ENG-PUDSP21010-R2-PUDSP.pdf Markup Summary

Subject: Image
Page Index: 1
Date: 1/18/2022 9:28:50 AM
Author: dsdparsons
Color: ■
Layer:
Space:
Page Label: [1] 1 COVER SHEET

C2.01
Sheet 7 of 40

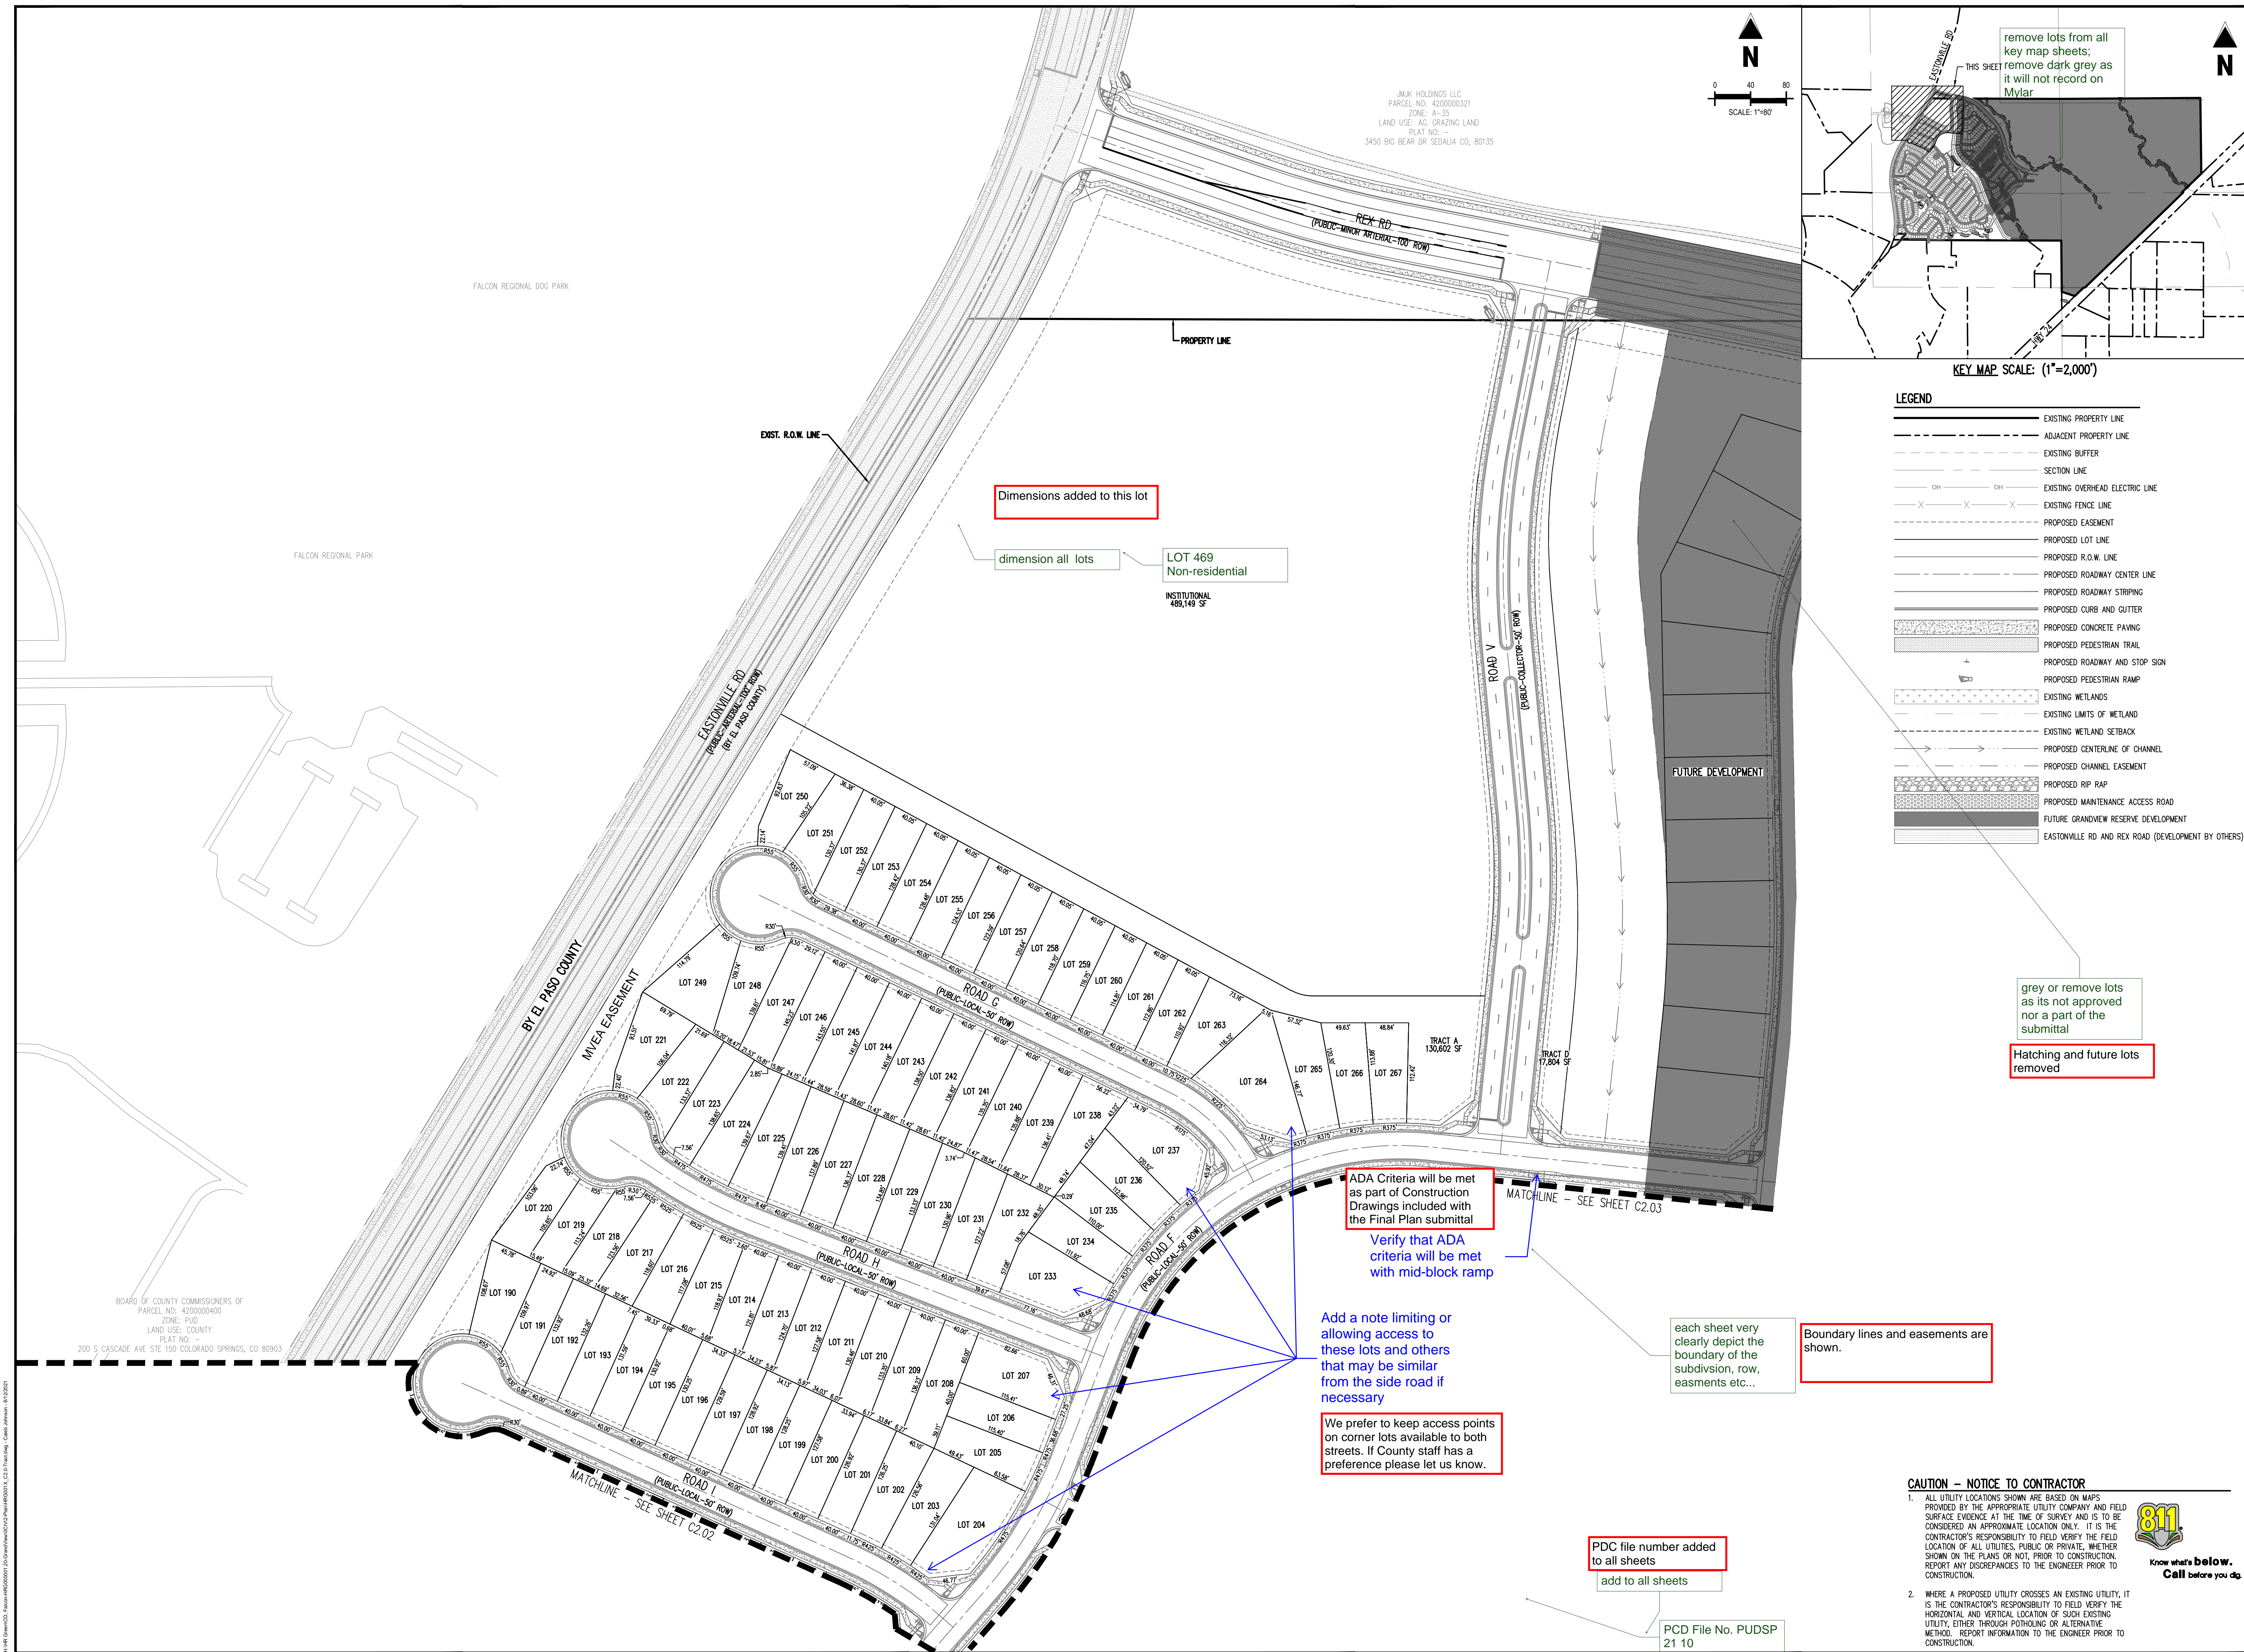
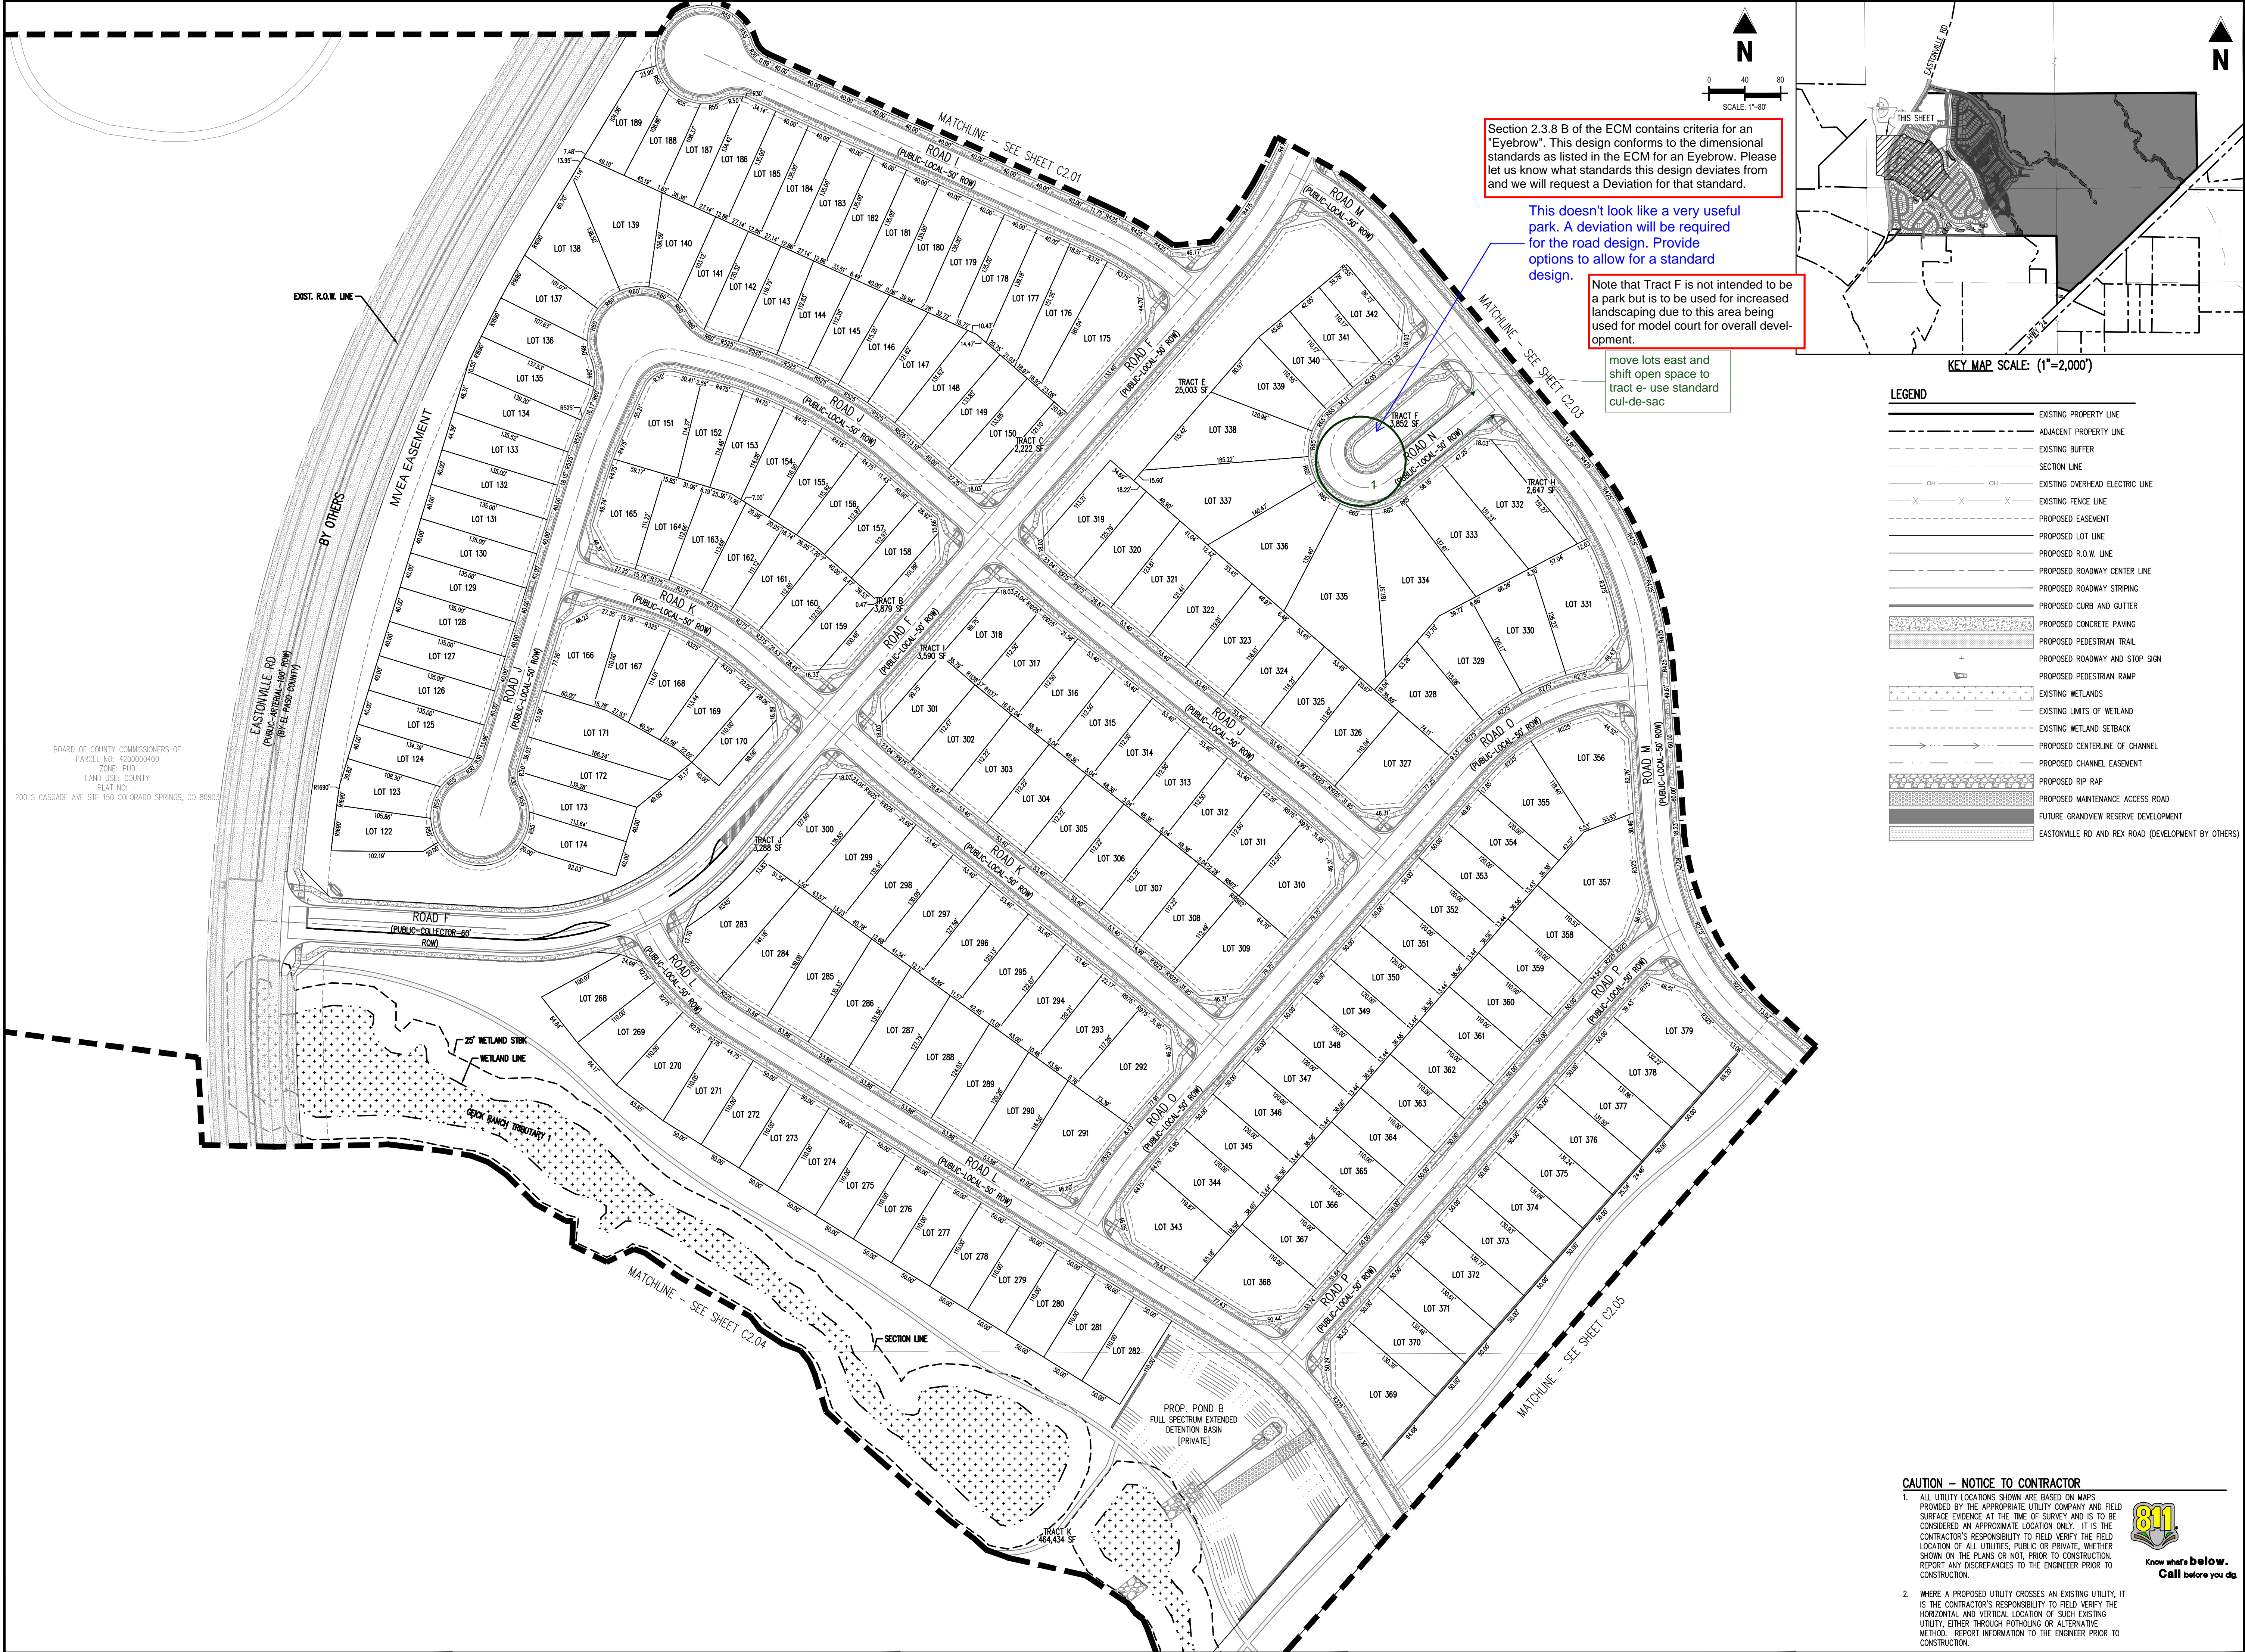
Ad SF to all lots

Adjust text

See comment letter (previous redlines unresolved)

show sight distance triangles on knuckle curves

revise matchline sheet numbers to match sheets?

C2.02
Sheet 8 of 40

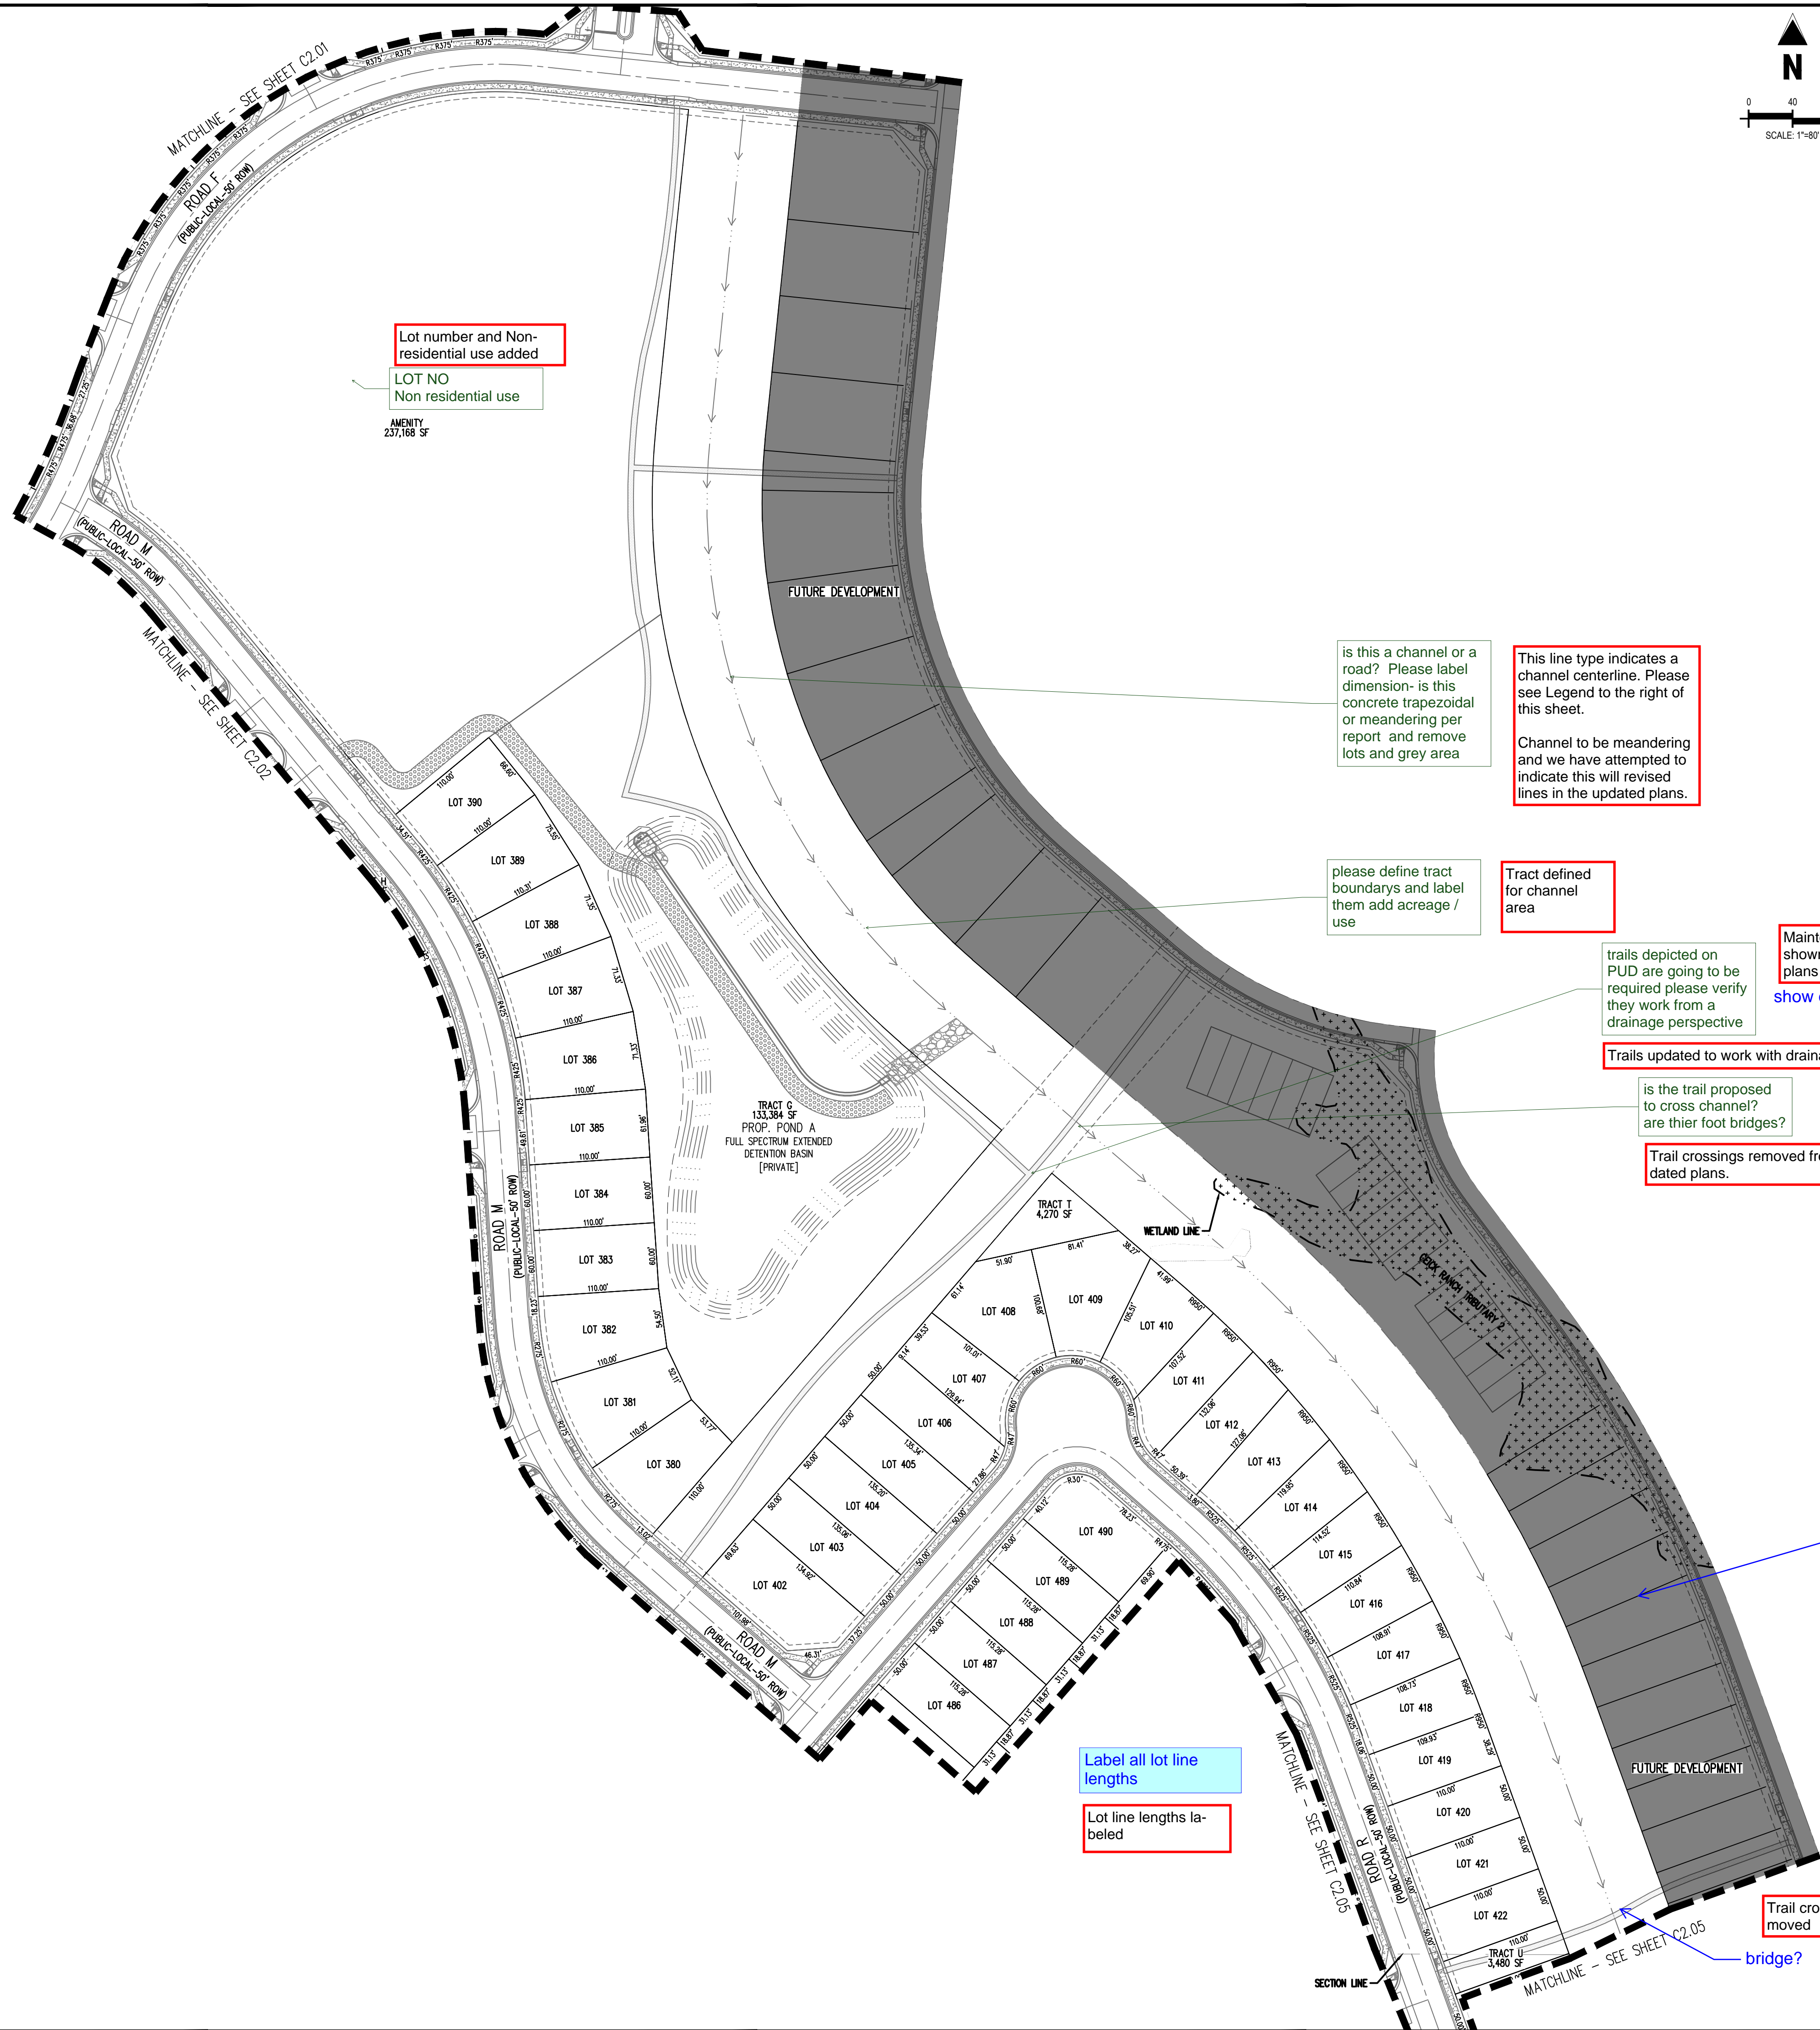
Does this double as a trail?

Add all lots SF, road names to each sheet

label lot line and boundary lengths

show sight distance triangles on knuckle curves
